Norfolk Vanguard Offshore Wind Farm

Statement of Common Ground

National Farmers Union

Applicant: Norfolk Vanguard Limited
Document Reference: Rep2 - SOCG - 5.1

Figure 1 – Hornsea Three, NV and NB (PEI) Project Boundaries

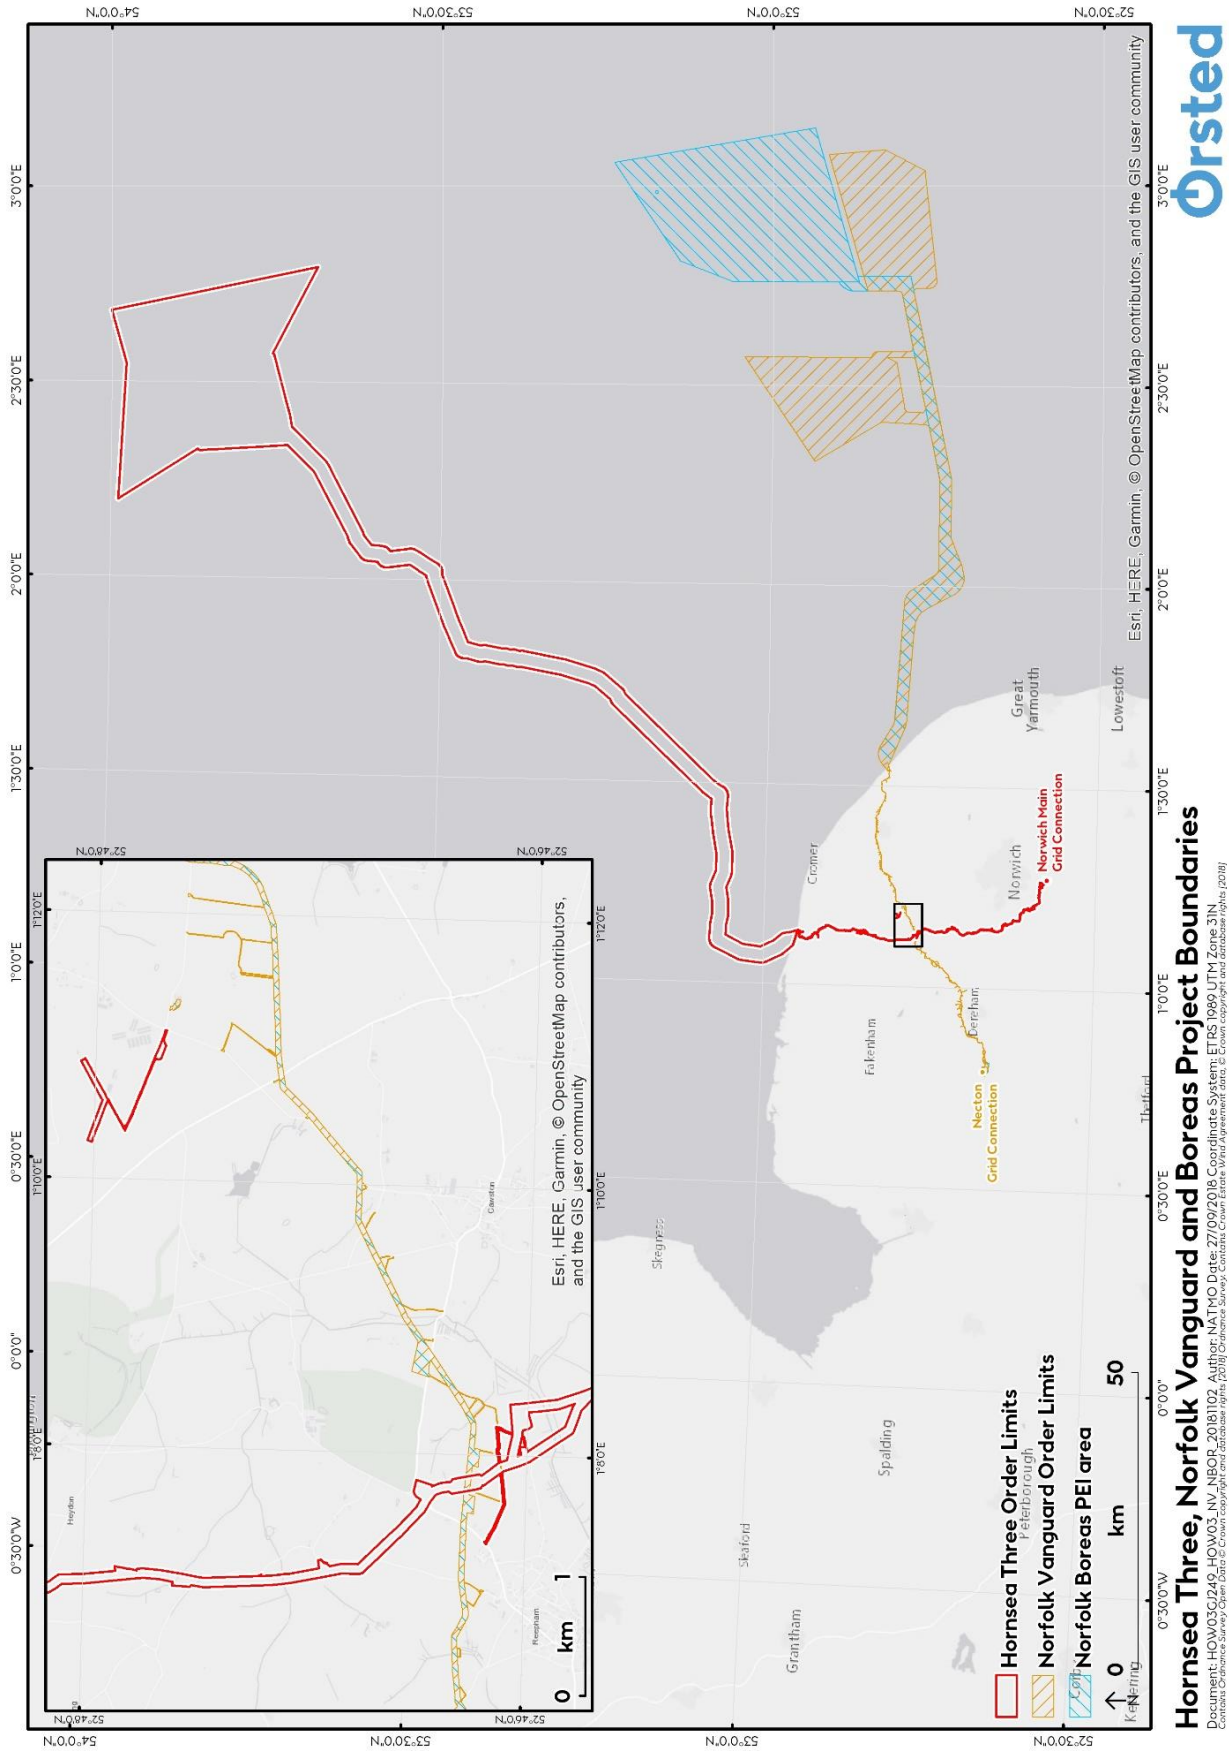
11.0 Crossing Point Orsted/Vattenfall: The NFU and LIG believe that it has still not been stated clearly how construction of the different cables will take place at the crossing point with the Orsted development in two phases and the Vanguard and Boreas proposed developments.

The Applicant has submitted a SoCG with Orsted Hornsea Project Three (UK) Ltd (Rep1 – SOCG – 18.1). The document notes, in response to Q1.13.3 of the ExA’s first written questions to the Hornsea Project Three examination, that as part of the co-operation agreement, the parties will agree a mechanism to determine the method and design at the point of crossing incorporating the principle that one project would install using open cut, and one through HDD.

The SoCG also notes that with respect to the co-operation agreement “both parties will design the cable installation works so as to ensure that the other parties can still install their cables – for example, if the first project installs the cables by way of open cut trench, that section of trenching will include enhanced thermal conductivity backfill to reduce any potential future thermal interactions with the second project.” Furthermore, “parties will share design specifications when known to help facilitate the design of the other party’s cables at the point of crossing”.

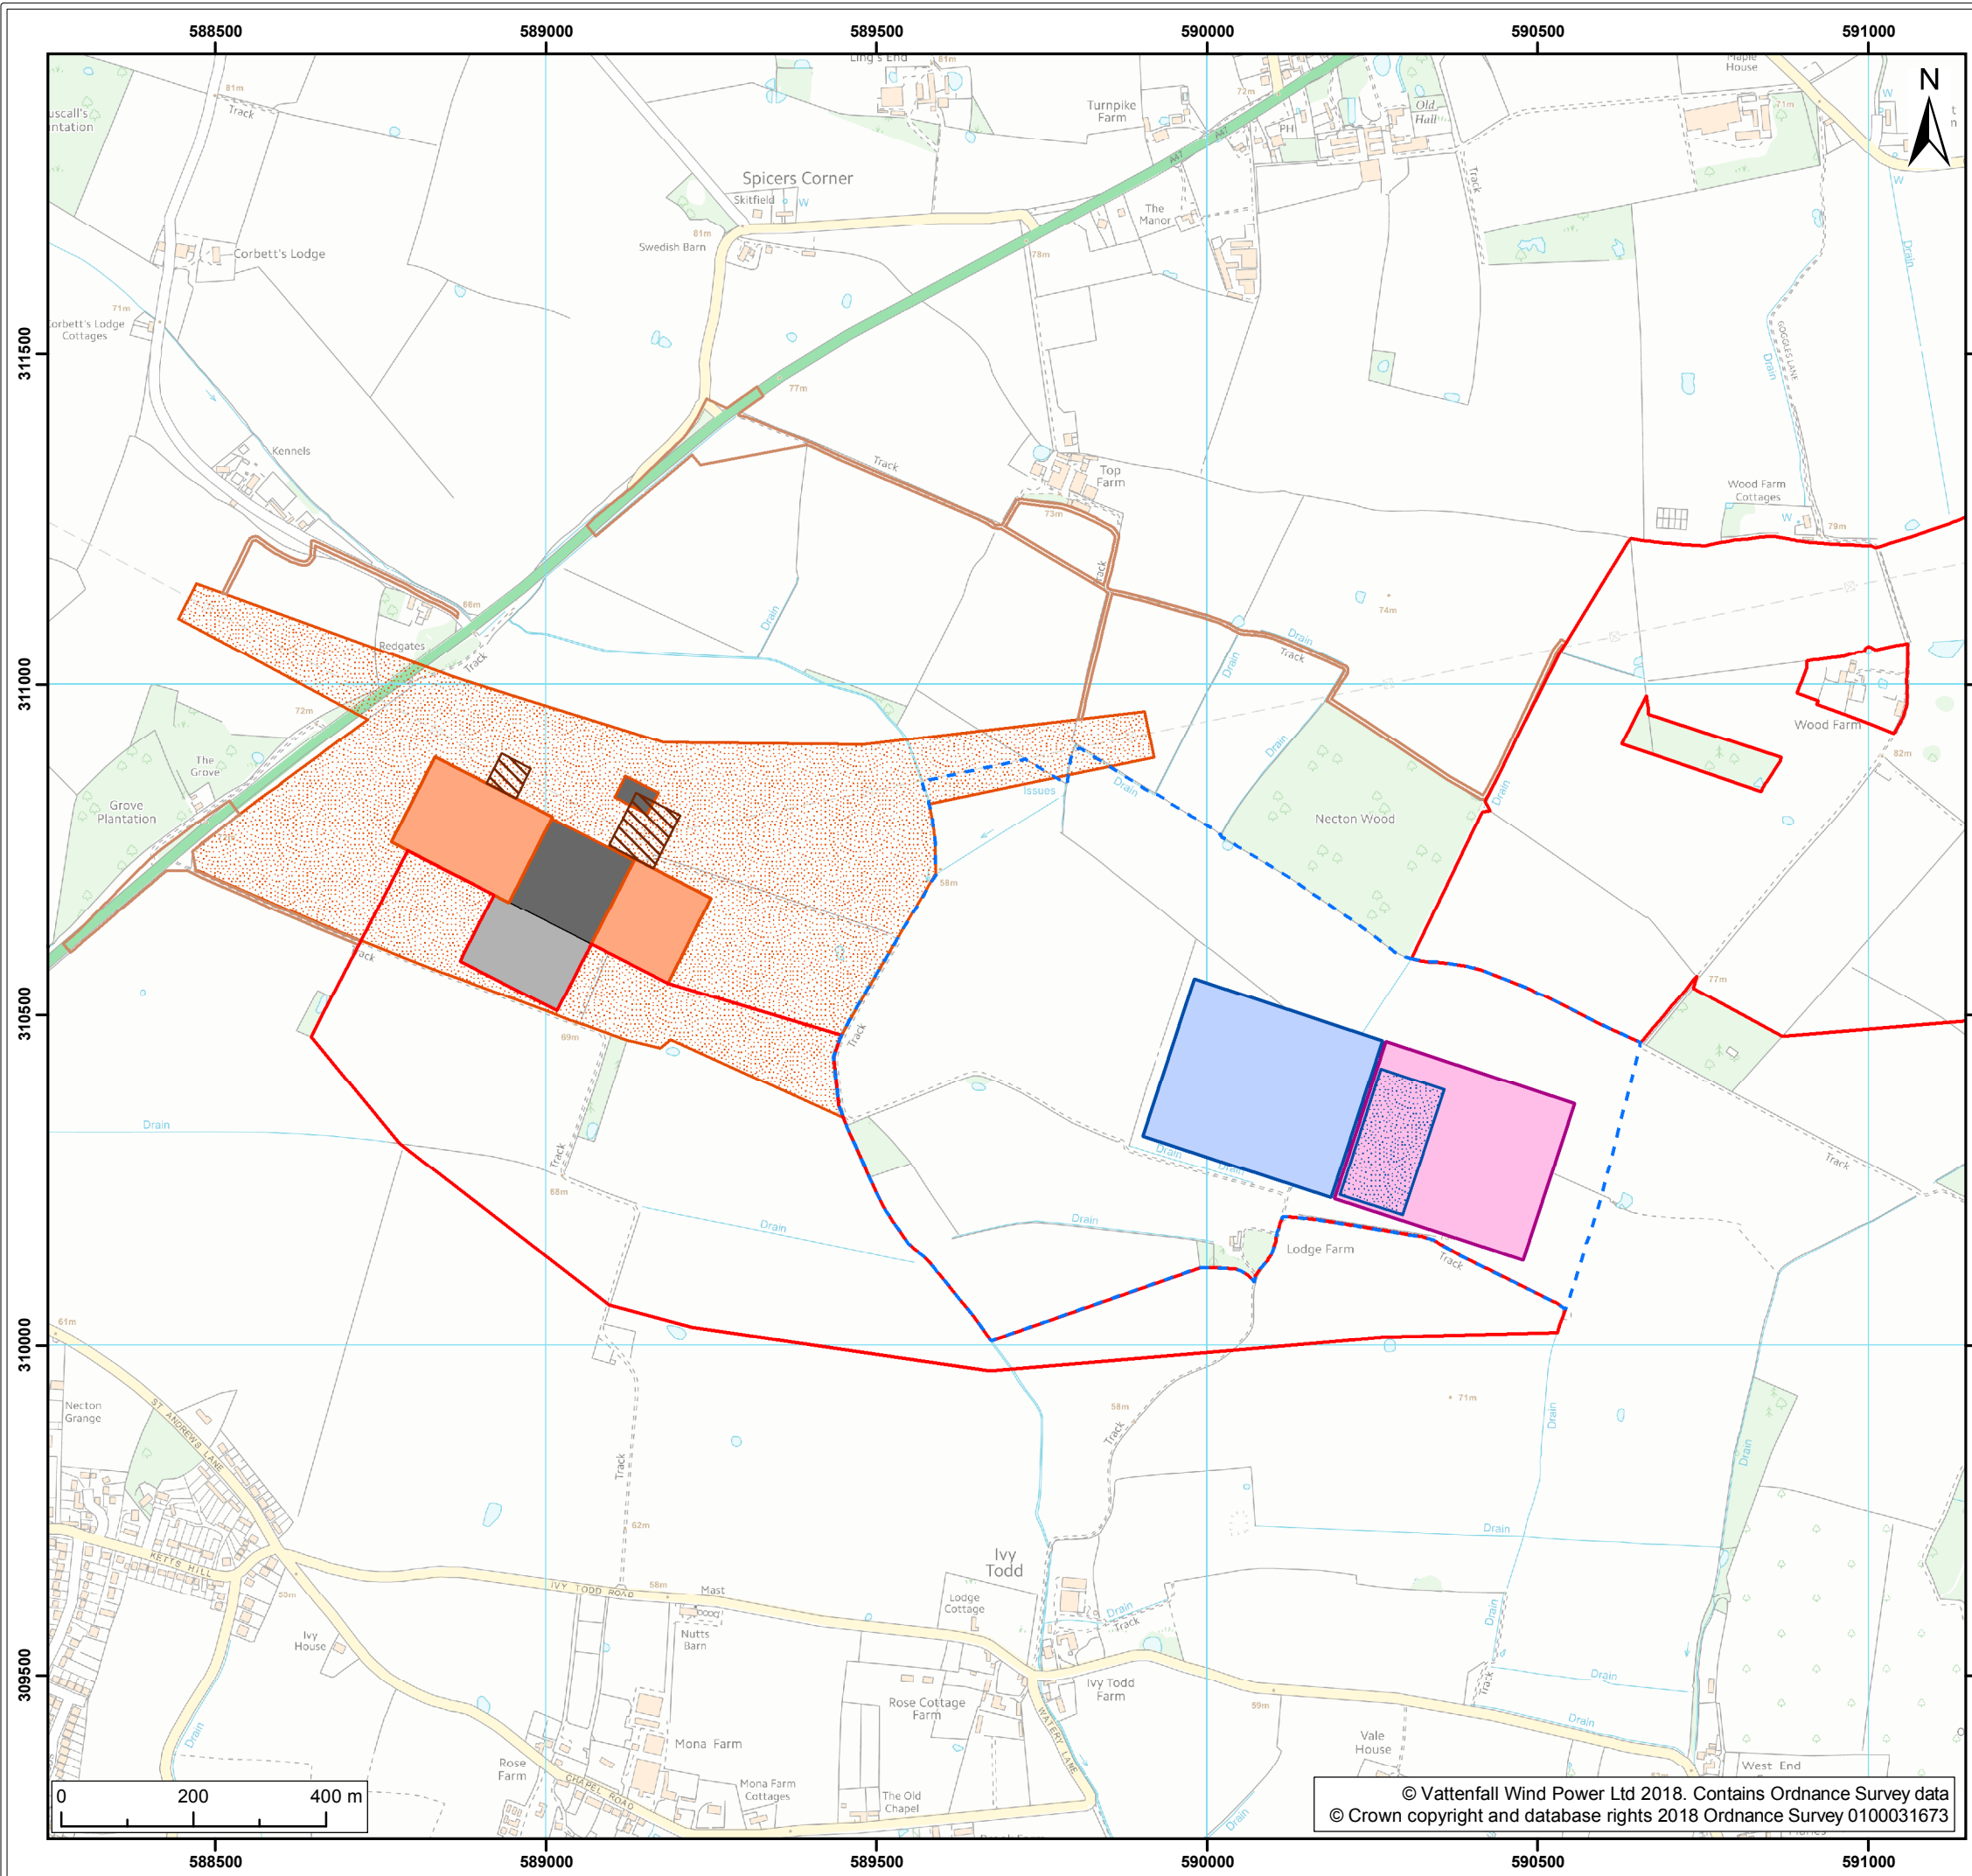
Why has such a prominent elevated site been chosen due to its visibility, particularly from the south and the west	<p>The Applicant will work to ensure that mitigation proposed is proportional to the scale of the substation infrastructure, and that it mitigates the overall impact on the local area. The key mitigation in relation to landscape and visual impacts of the project substation is its location. The proposed location for the onshore project substation makes effective use of topographic undulations and existing natural screening in the form of Necton Wood and existing hedgerows. The process of identifying the preferred onshore project substation site is set out in ES Chapter 4 Site Selection and Alternatives, and a detailed assessment of visual impacts is presented in ES Chapter 29 Landscape and Visual Impact Assessment (both DCO doc ref. 6.1). Chapter 29 also provides details of the mitigation that has been committed to in order to further reduce potential visual impacts. This includes:</p> <p>Additional mitigation planting to enhance the screening effect of existing hedgerows and woodland blocks in the local area. The location of this planting and photomontages/visualisations are provided in Chapter 29 of the Environmental Statement.</p> <p>Bunds, or earth mounds, will be constructed where possible to increase the base height and maximise the effectiveness of mitigation planting as screening.</p> <p>Mitigation planting will comprise faster growing ‘nurse’ species and slower growing ‘core’ species. Core species with an average growth rate of 250mm per annum will provide 5m to 7m of growth after 20 years which will characterise the woodland structure over the long term. Nurse species would be faster growing (350mm per annum) to provide 7m to 8m of screening after 20 years.</p>	Outstanding

<p>Questions as to why site is not close to the</p>		<p>Appendix 4.9 of the ES Chapter 4 Site Selection and Alternatives - Onshore Project Substation Site Selection (doc ref 6.2.4.9)</p> <p>(see response above)</p>	<p>Outstanding</p>

National Grid substation, which is not as visible		
	Screening provided by land form and existing features has not been taken advantage of	Appendix 4.9 of the ES Chapter 4 Site Selection and Alternatives - Onshore Project Substation Site Selection (doc ref 6.2.4.9) (see response above)	Outstanding
Construction and funding	Further clarification needed on timings of construction and how construction will take place for the Boreas scheme	Final project timings for both Norfolk Vanguard and Norfolk Boreas cannot be provided until post-consent and subject to a Financial Investment Decision for the projects. Further information will be detailed in the Option Agreement. This has been discussed with the LIG and detailed in the HOTs regarding compensation for compounds and working areas.	Outstanding
	Confirmation is sought whether Vattenfall have the funding required for both schemes.	The details on funding are provided in the Funding Statement (Document Reference 4.2).	Outstanding

<p>Where advanced planting can be achieved (in areas not affected by the construction works), this will commence in 2020 which will provide a minimum 3 years of growth prior to commencement of operation which equates to approximately 1.2m of additional growth.</p> <p>This information was also made available pre-examination in the information sheet – Onshore project Substation, accessible via the project website: https://corporate.vattenfall.co.uk/contentassets/bf0e5e31bbab467eaf02040c7b17513a/180-vattenfall-substation-info-sheet.pdf</p> <p>Issues related to visual impact and mitigation have been considered in part or in full in the following submission documents: Chapter 4 of the ES Site Selection and Alternatives (doc ref 6.1 – all ES chapters)</p> <p>Chapter 29 of the ES – Landscape and Visual Impact Assessment Section 17 of the Consultation Report – Overview of Non-Statutory Consultation and influence on the Project (doc ref 5.1) Section 23 of the Consultation Report – Summary of responses Received under Section 47 of the 2008 Act Appendix 4.2 of the Consultation Report – FAQ Documents Appendix 12.7 of the Consultation Report - Phase I Non-Statutory Exhibition Materials Appendix 12.8 of the Consultation Report – Phase II Non-Statutory Exhibition Materials Appendix 14.1 of the Consultation Report – June 2017 Newsletter Appendix 14.8 of the Consultation Report – Necton Substation Workshop Presentations Appendix 20.10 of the Consultation Report - Formal Consultation Public Exhibition Boards Appendix 20.14 of the Consultation Report – February 2018 Newsletter Appendix 22.1 of the Consultation Report – Section 42 Responses and regard had by the Applicant Design and Access Statement, section 5.2 (doc ref 8.3).</p>
